Date 19 January 2024  
Our Ref 24/00022/FUL

**Town and Country Planning Act 1990 (As Amended)**  
**Car Park, Upper High Street, Epsom**  
**New dry valeting area with an additional canopy & groundworks to provide drainage to existing wet car wash area.**

TITLE  
**SITE LOCATION PLAN**

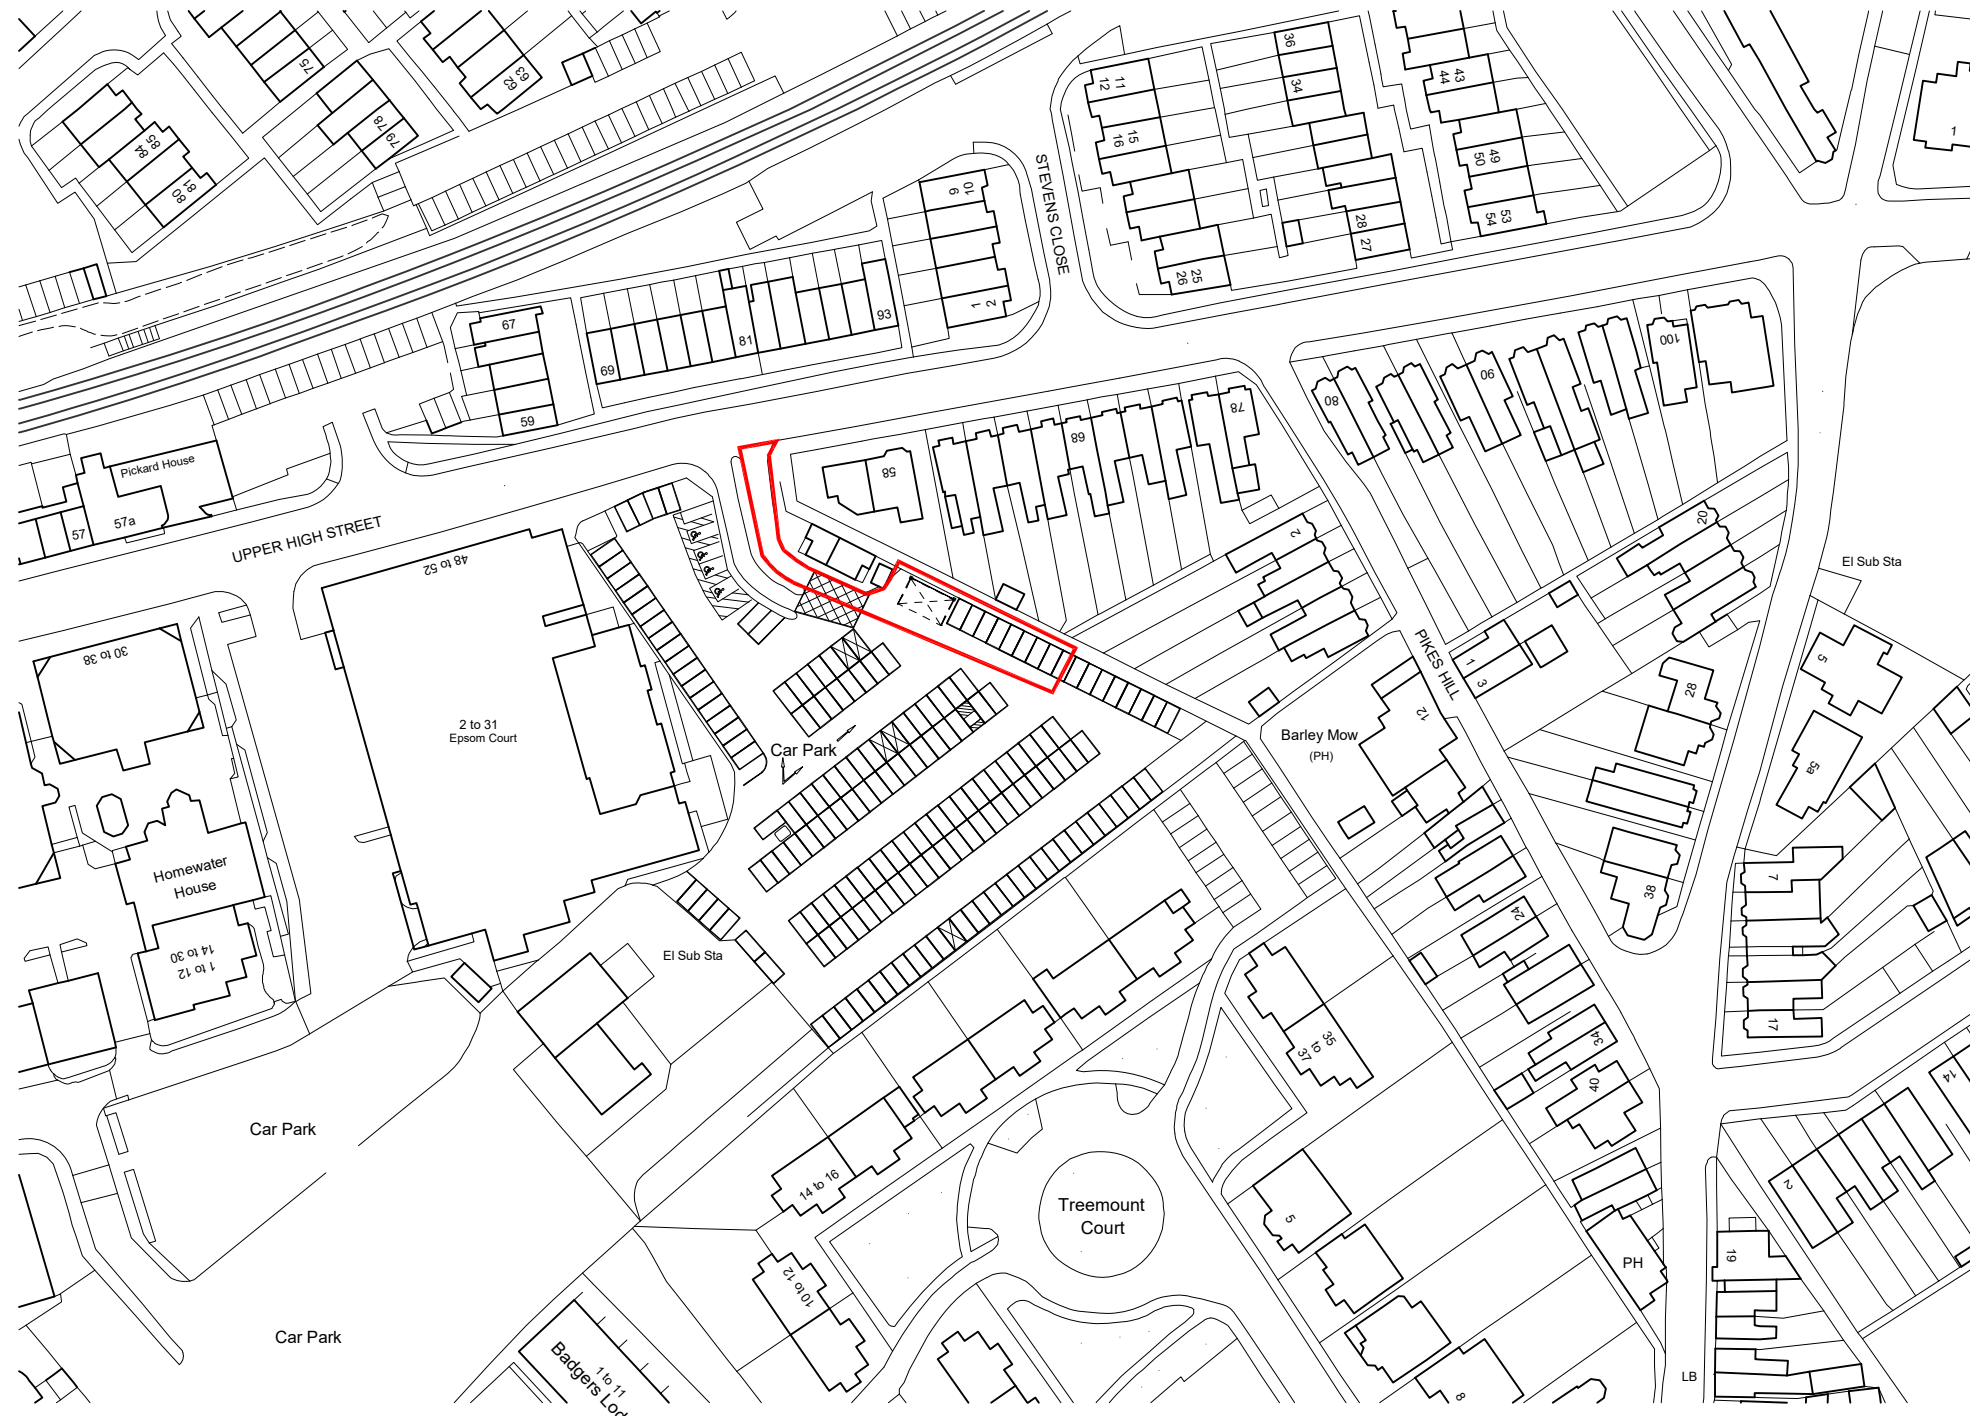
1 The Location Plan is incomplete. Please re-submit the plan which is to include a continuous red line, drawn around all the land necessary to carry out the development (including land required for access to the site from a public highway, visibility splays, landscaping, car parking and open areas around the building up to the site boundaries and beyond (if appropriate). If applicable, include a blue line around all other land owned or controlled by the applicant/landowner close to or adjoining the application site
